12 September 2024

**Re: SSD-49472213 - 50-88 Parraween Street and 59-67 Gerard Street Cremorne - Seniors Housing Proposal - Amended Application.**

1 **SOUTHEAST ELEVATION**
(PARRAWEEEN STREET)

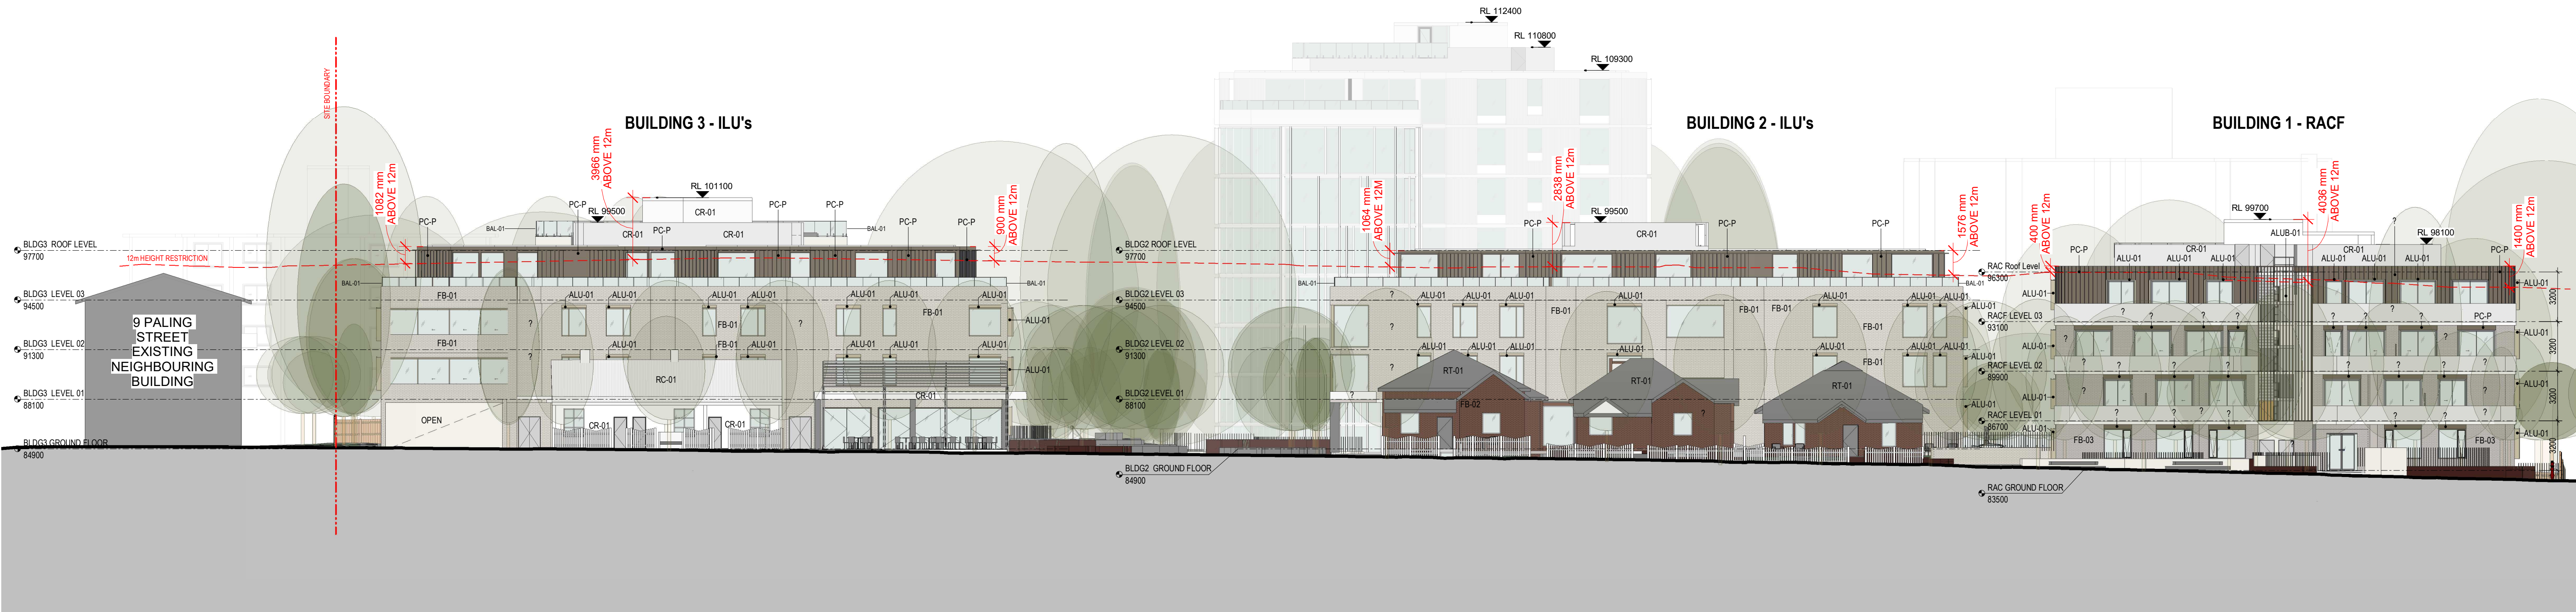
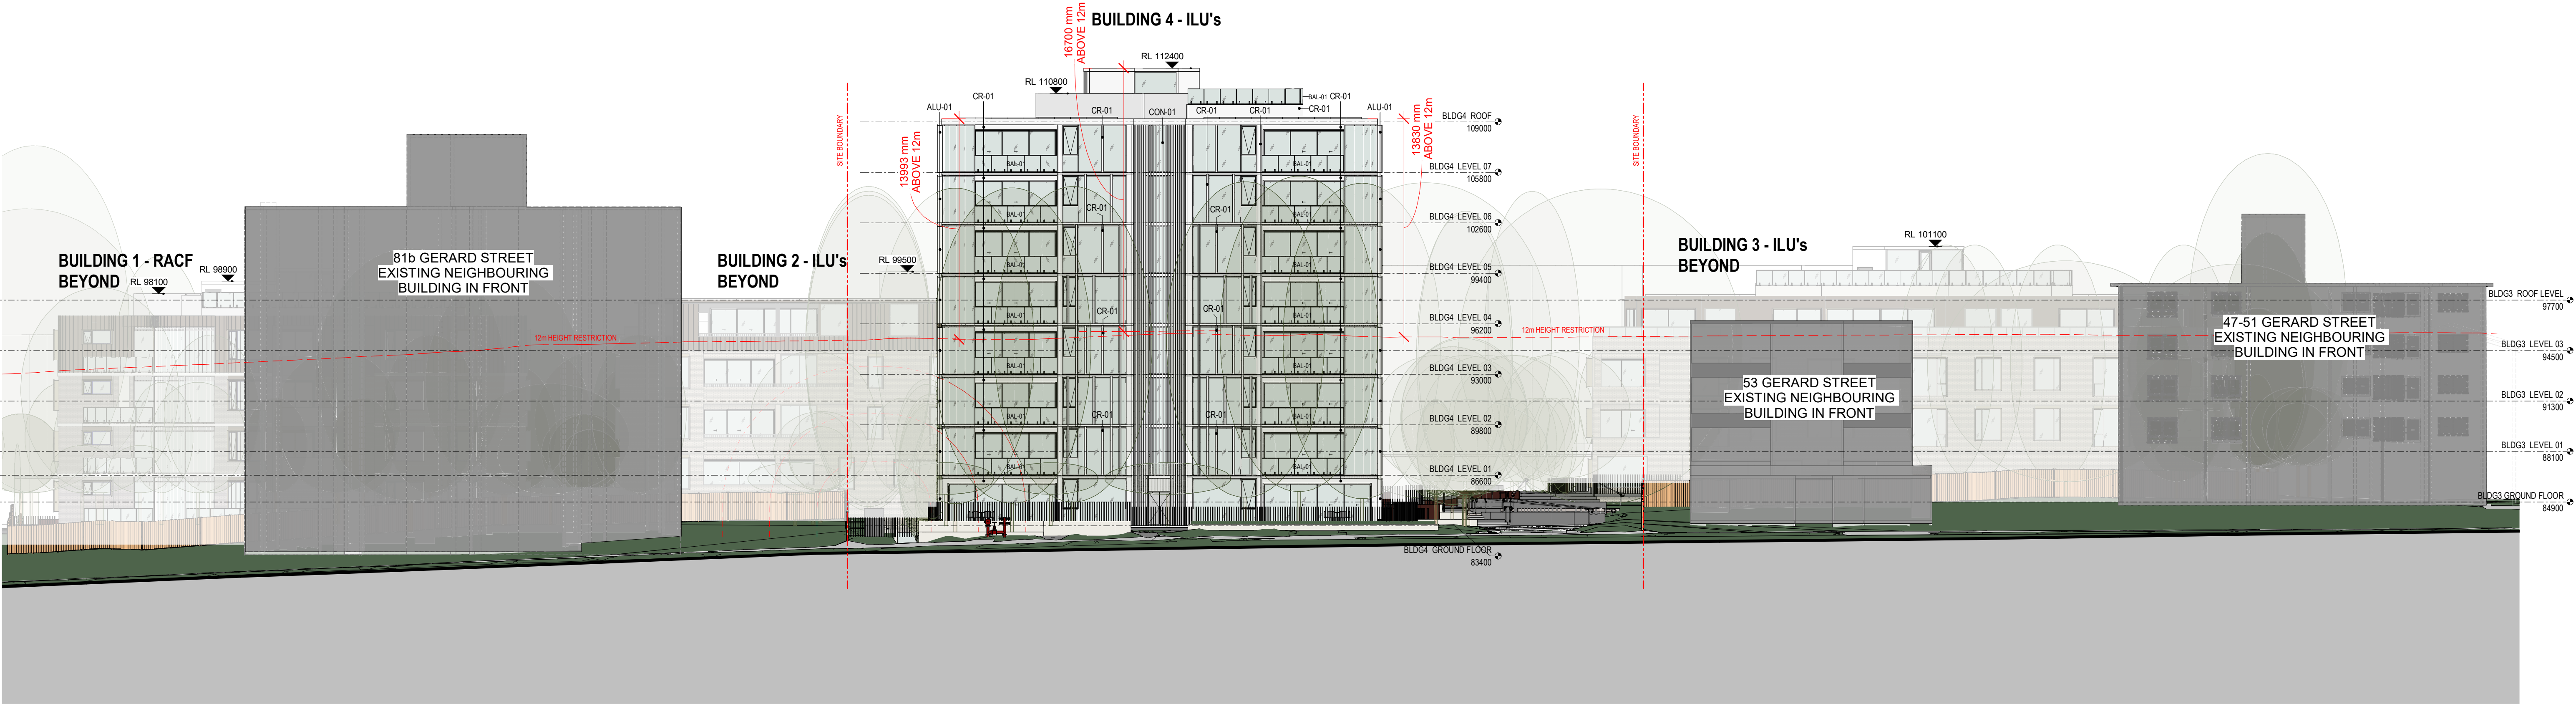
1. Built form and scale of Building 4: The resultant built form and scale of Building 4 to Gerard Street remains significantly greater than a height compliant building and appears to rely on the context and scale of existing adjoining buildings, including those at Nos. 81A and 81B Gerard Street, which were approved under early planning controls as one basis for the significant height variation proposed. The form of Building 4 remains inappropriate in scale and is not in accordance with, nor adequately responds to the existing and desired future character of the area.

2. Extent of shadow cast by Building 4: The shadow impacts arising from non-compliant elements of Building 4 while reduced, still result in significant and unreasonable impacts within the development itself and to the proposed publicly accessible plaza.

3. The shadowing effects are unreasonable: The breaches to the height standard arising from Building 4 should be regarded as excessive and unreasonable considering the finished levels of the plazas and ground floor plane of Building 2.

ADDITIONAL CANOPY TREES

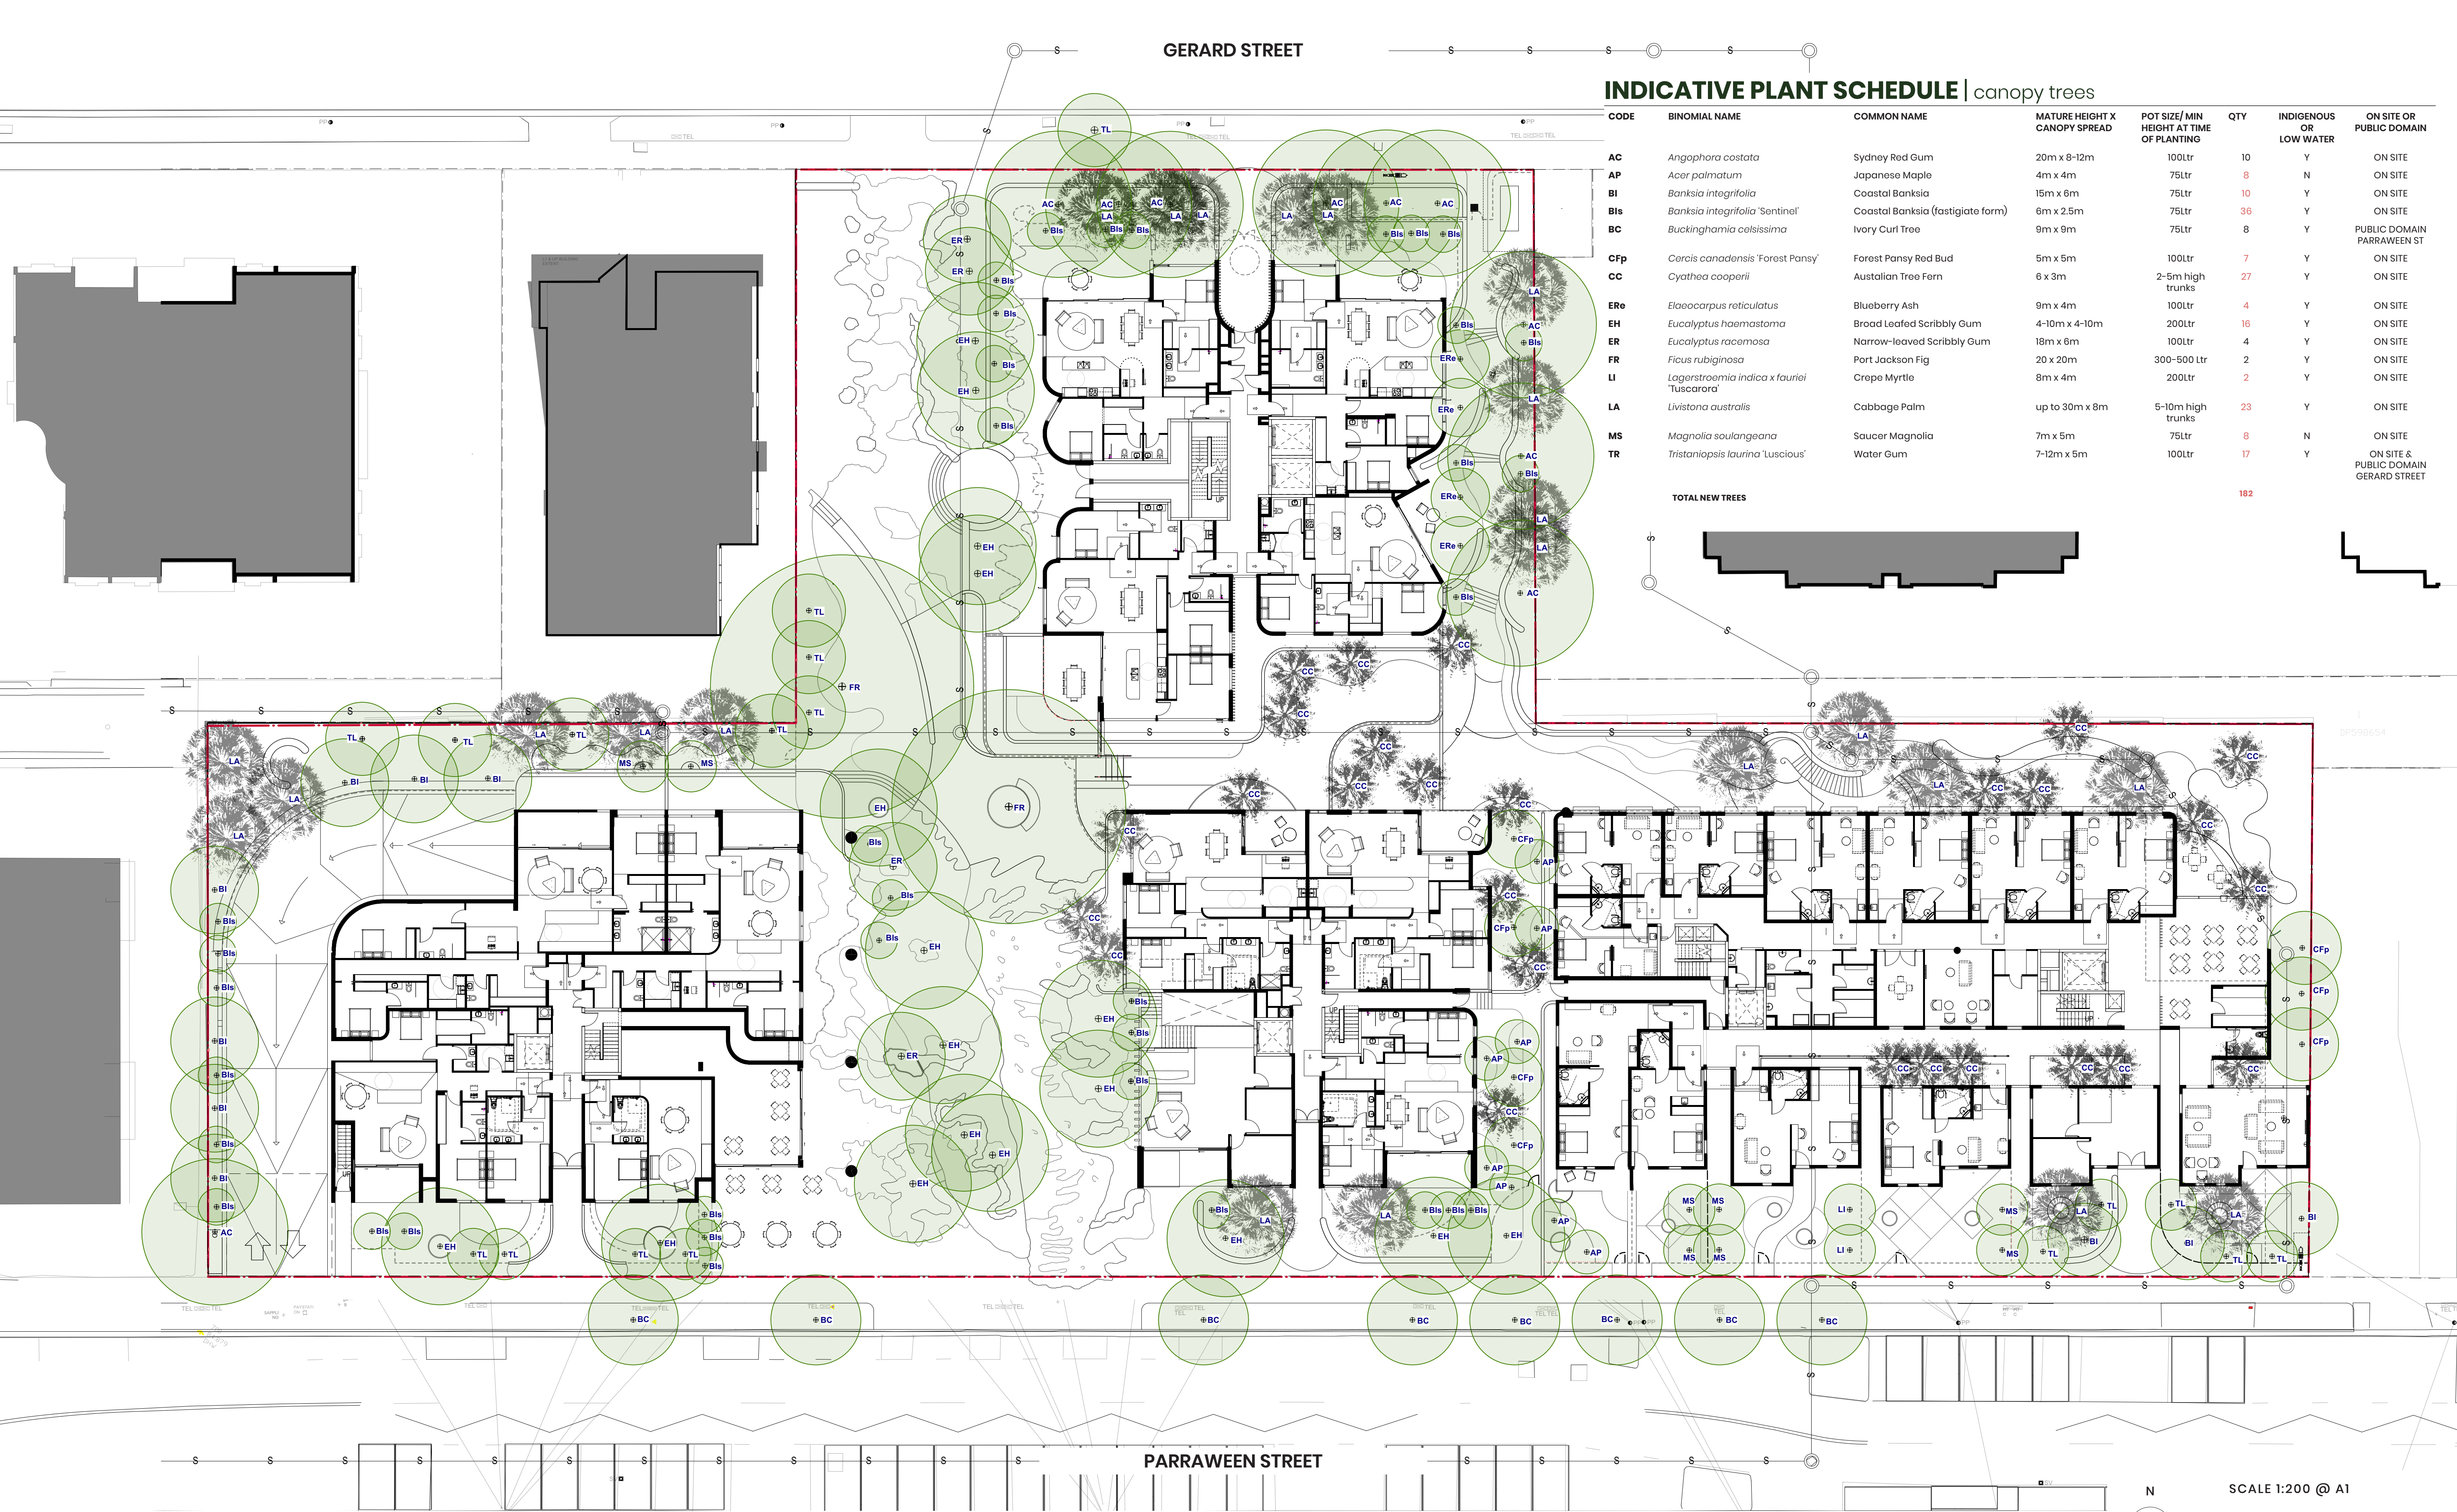
Council's position, however, is maintained that the proposal will result in unacceptable canopy loss and the changes noted within the application do not materially address the concerns raised by Council's original submission. The proposal remains inconsistent with one of the key objectives of Council's Urban Forest Strategy (2019) being to maintain and increase the totality of trees and vegetation across the North Sydney area.

Should permission for removal be granted, suitable mature replacement canopy trees must be provided. All trees shown for retention shall be protected in accordance with recommendations of a consulting arborist which ensures compliance with Australian Standard AS4970.
